BCA COMPLIANCE REPORT

BAY 4 & 5

1-3 HICKSON ROAD THE ROCKS

Report PR-425/2016-cl94

Drawing Title
DEMOLISHED & PROPOSED SECTION H-H

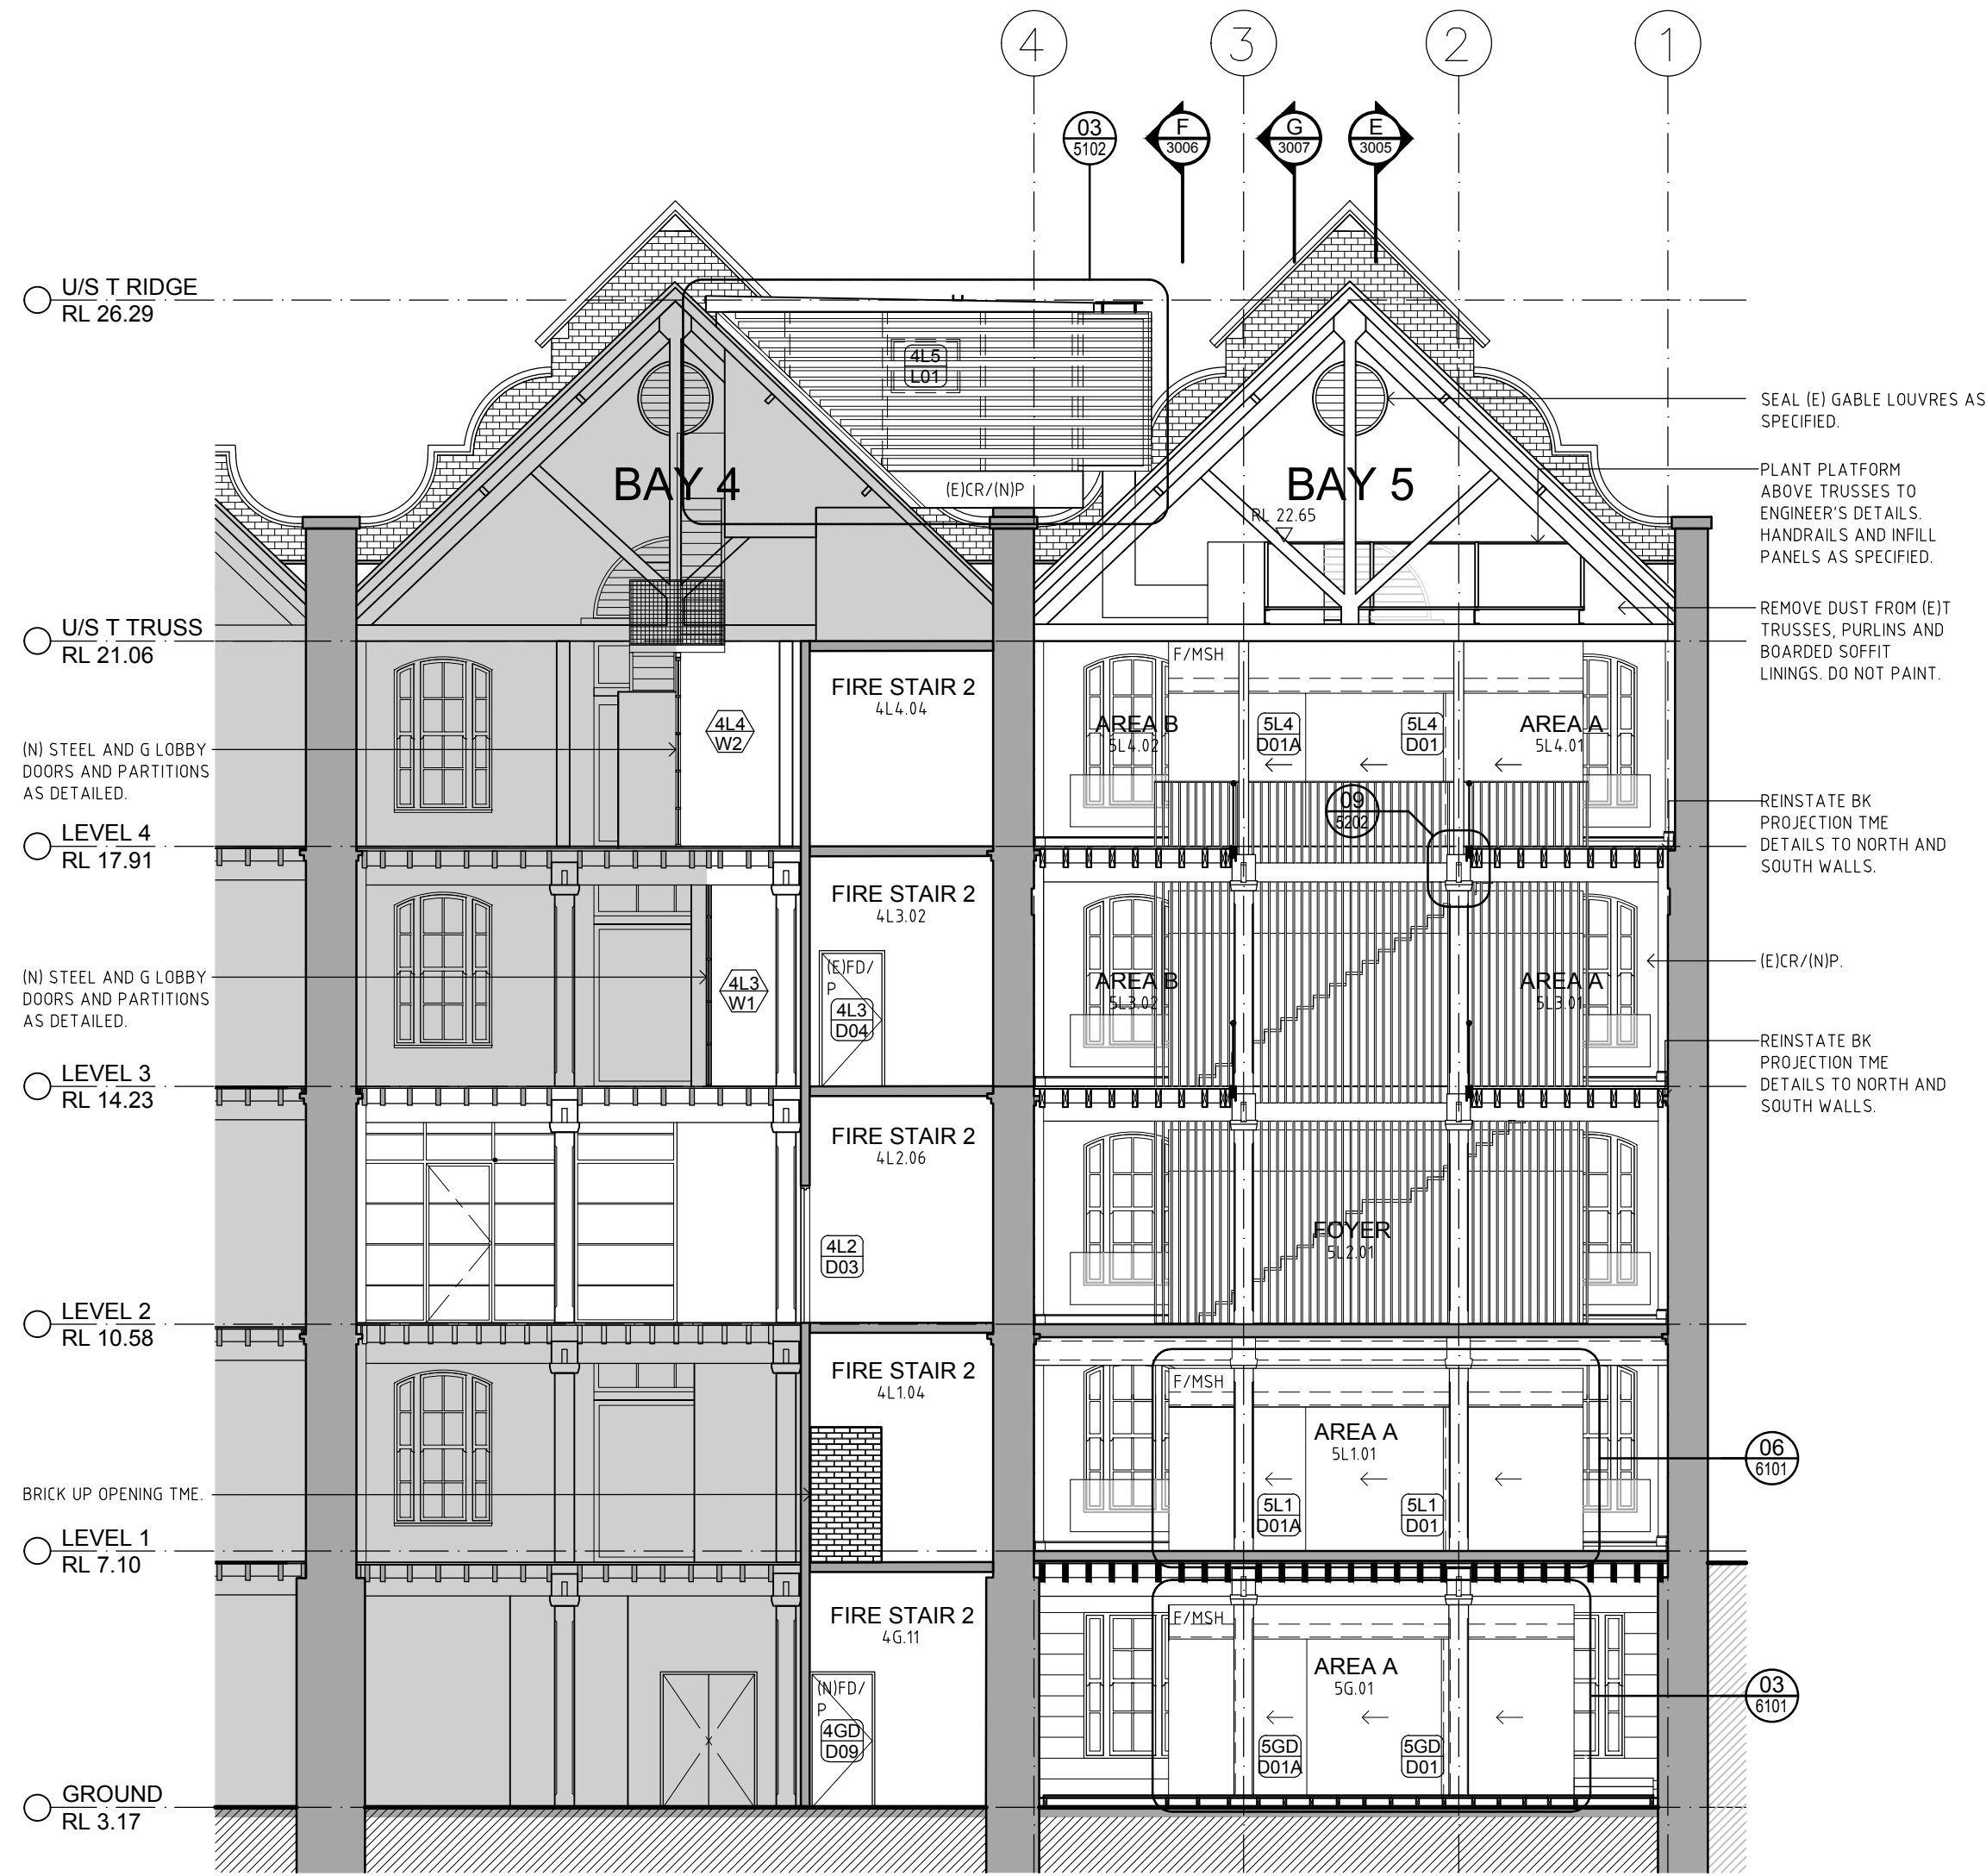
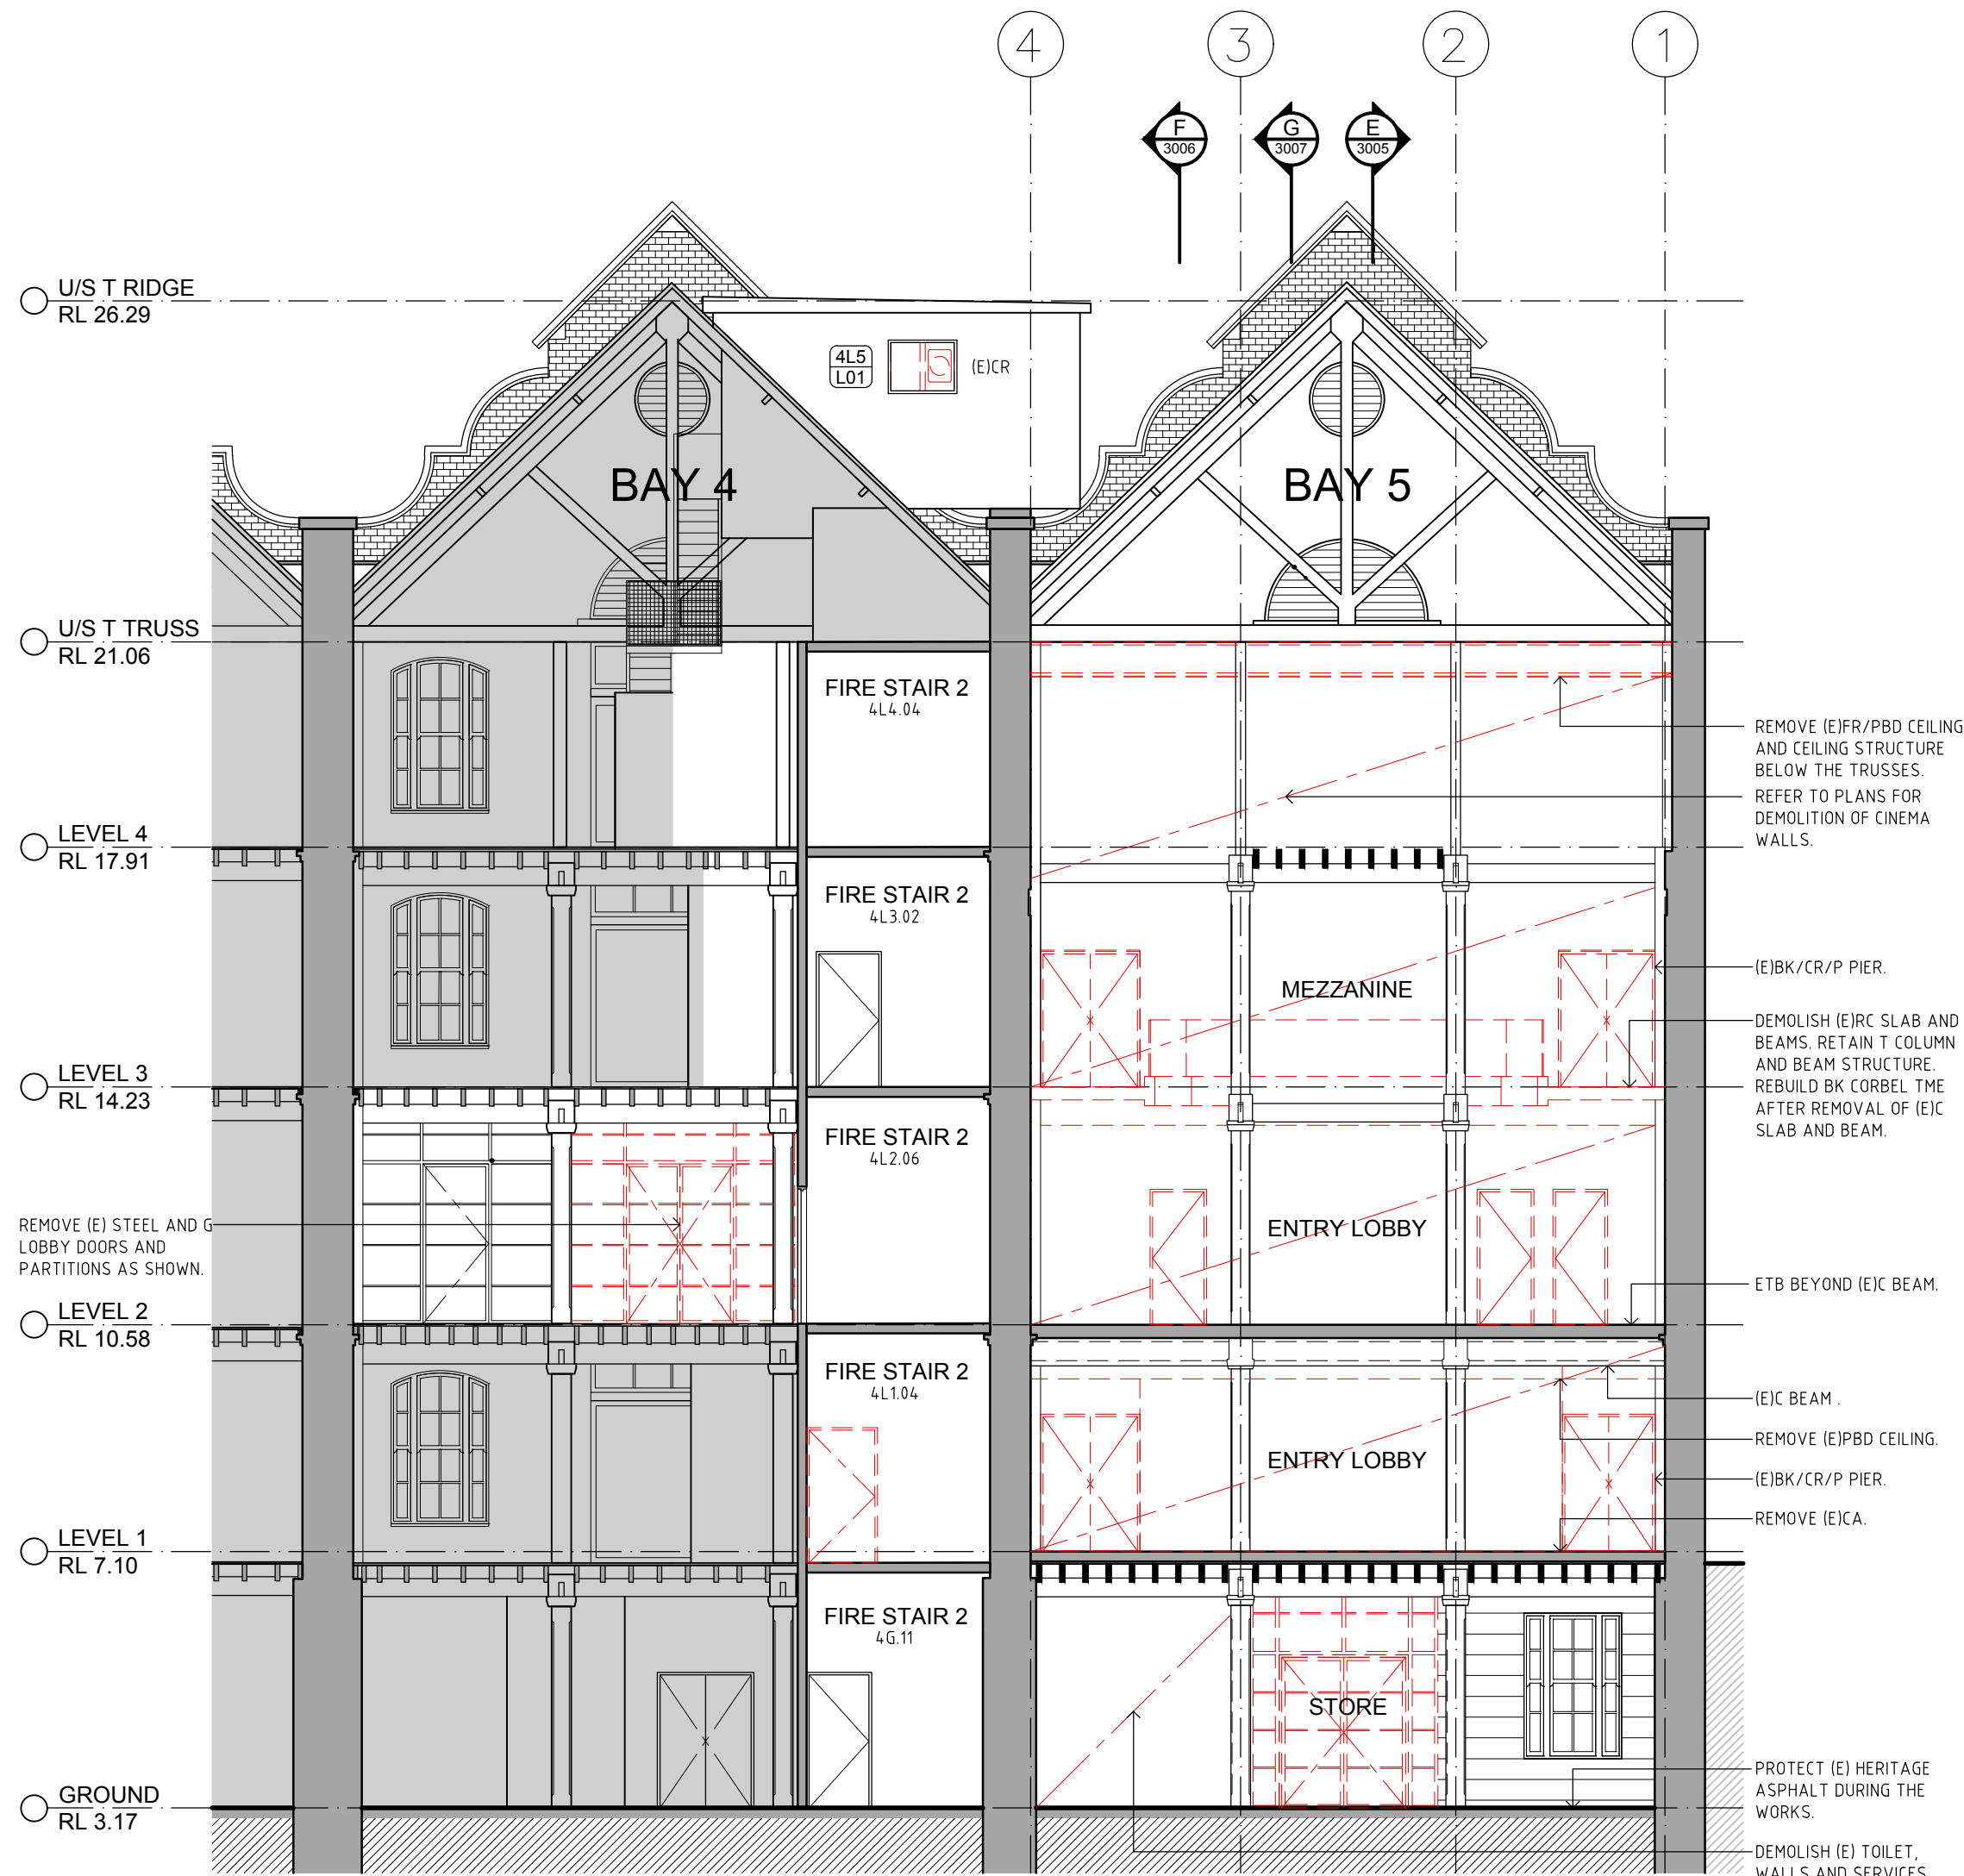
BCA-Dts NON - COMPLIANCE BAY 4 & 5	PARTICULARS	PERFORMANCE MEASURES
Clause C1.10 & Specification C1.10 - Fire hazard properties	Fire hazard properties associated with the timber floor /ceiling construction does not satisfy the fire hazard properties of Clause C1.10 & Specification C1.10.	CP4
C2.12 Separation of equipment	Existing fire pump room within Bay 2 is not fire separated from the remainder of the building.	CP2 & CP6
Clause C2.9 Separation of classifications in different storey's	Classifications between storey's results in class 5 & Class 9b uses that are not fire separated between storey's - Bay 2-4.	CP2
Clause C3.12 Openings in floors and ceilings for services	Requirements of C3.12 are not able to be satisfied due to the absence of fire rated construction associated with the floor construction between storey's.	CP8
Specification C1.1- FRL construction building elements Table 3 –Type A construction	Existing and proposed buildings elements such as floors, beams and columns do not achieve any fire resistance level of construction.	CP1,CP2 & CP4
